A/39/26/L

Address: Margarets Church Arundel Road Angmering BN16 4JS

Proposal: Listed building consent for the installation of a single commemorative blue plaque on the external Vestry wall.

Angmering Parish Council
14805 - Aubrey Plaque V1.2

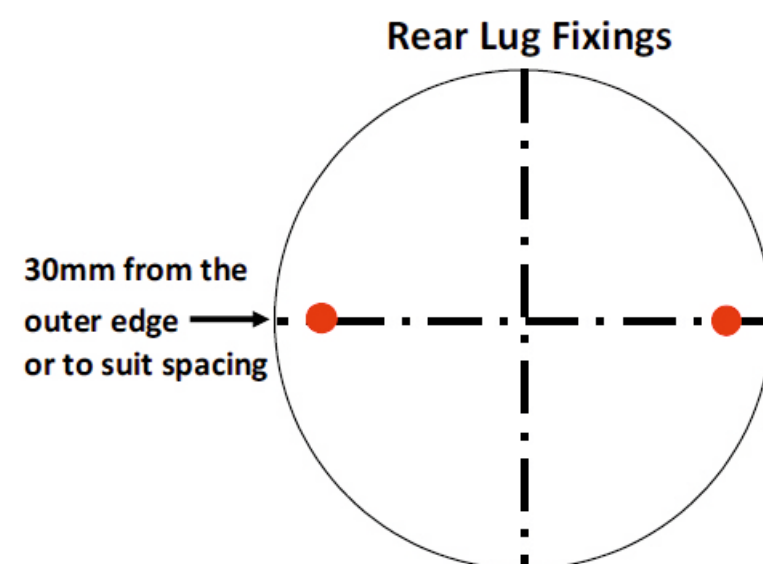
The plaque would be located on the corner of the building and be placed so that it would be clearly visible from the road, car park and general surroundings. It is assumed that it would be located on the brick detailing as indicated in the images supplied. Although it is not clear how high up the building it would be located – you may wish to get this confirmed. The design of the plaque also looks to be acceptable in this sensitive context.

It is positive to note from the application that the installation will have minimal impact on historic fabric due to the use of reversible fixings placed in existing mortar joints. As a result, no historic fabric would be damaged.
